Director
Key Sites Assessments
GPO Box 39
Sydney NSW 2001
NSW Department of Planning & Environment
State Significant Development.
Application No. **SSD 7693**

IMPACT ASSESSMENT REVIEW

The Astor Apartments.- 123- 125 Macquarie St.

Submission - Intercontinental Hotel- Alterations & Additions. Concept DA (Stage 1) that seeks approval for building envelopes to facilitate external alterations and additions and internal alterations and upgrade works to the Intercontinental Hotel, extending over part of Transport House.

LEVEL 31A TOWER FLOOR PLAN
FLOOR PLAN SHOWING NEW ELEMENTS

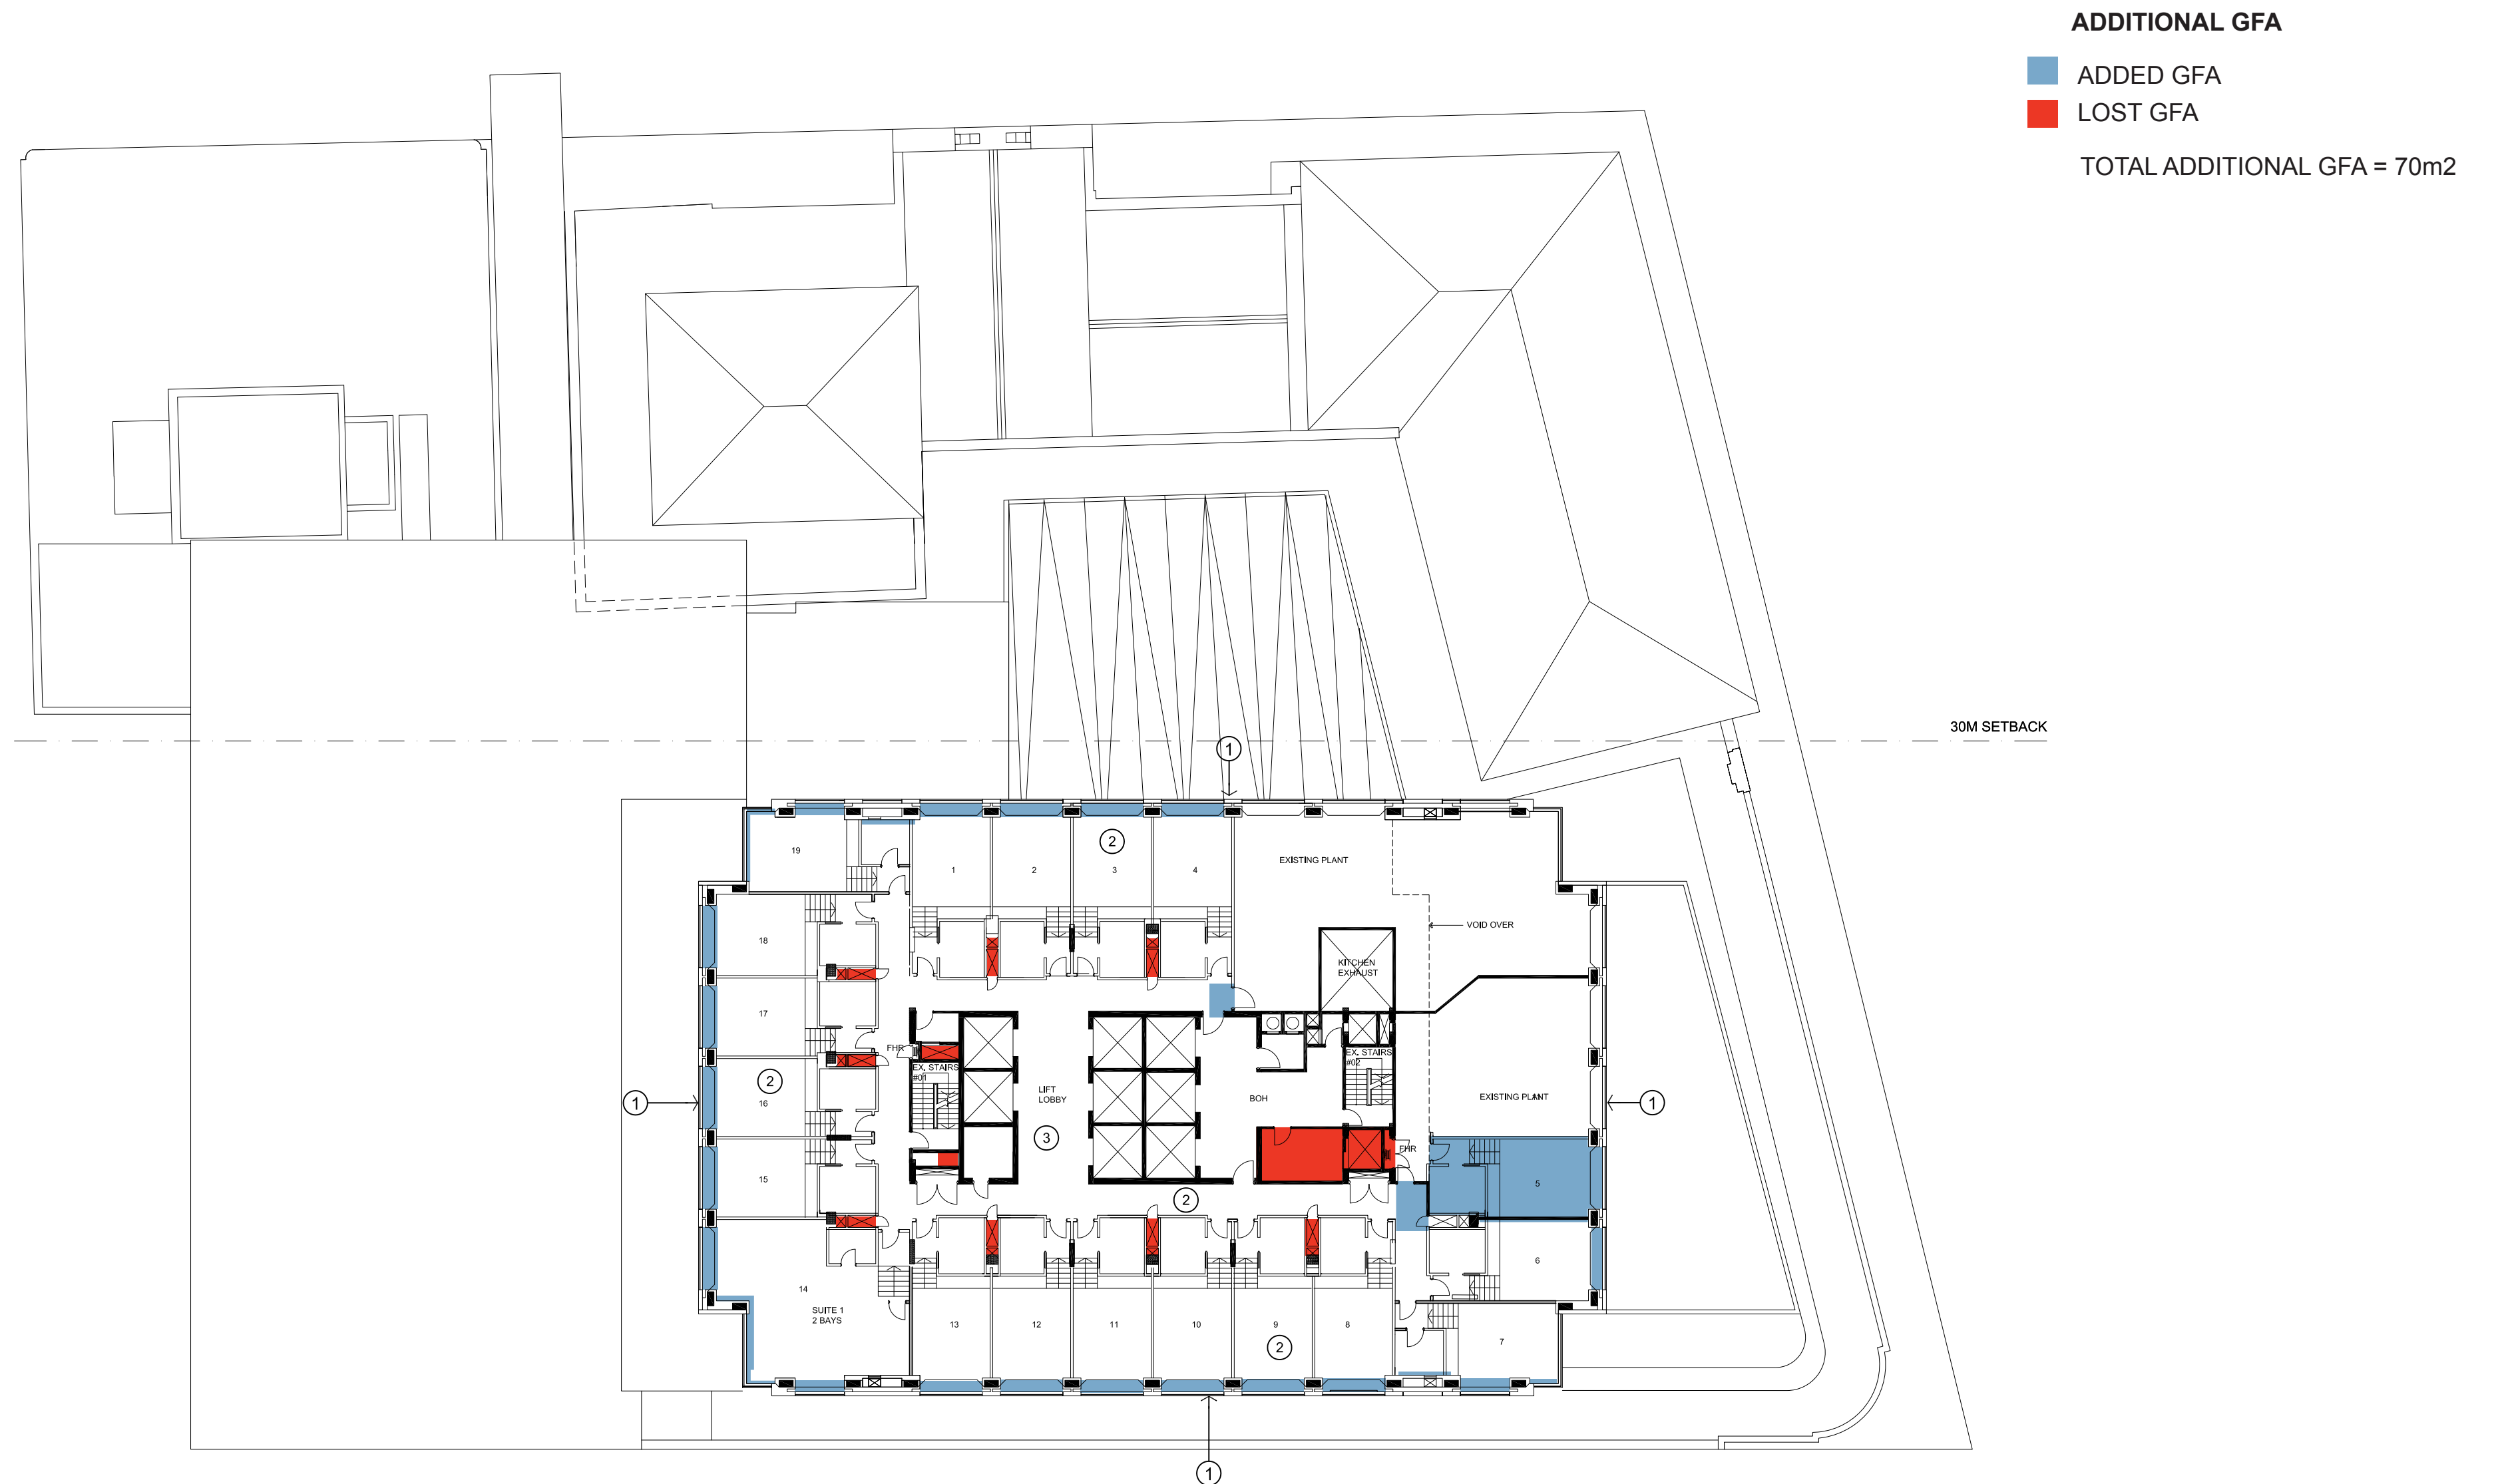
No reference is made to the rooftop development of the Club Lounge extension on Level 32 to the Bridge St elevation, which is located at approximately 60 m from the Astor apartment's north facing windows. From our assessment of the limited detailed information provided, this includes Public balcony areas to the full extent of the southern elevation, off the function suite and terrace, at a Reference Level height of 109 m.

The increase in the floor area of this public function area will have significant impact on the privacy of the occupants to the upper floors and to the common roof area of the Astor Apartments. In potentially allowing patrons to have unimpeded line of sight into all north facing rooms of private residences, as well as visual access to the common roof area; the proposal in its current form, has not demonstrated how this impact could be reduced or even considered.

It is requested that the full extent of this potential impact be assessed in relation to the privacy of the North facing apartments as well as the public roof area of the Astor building.
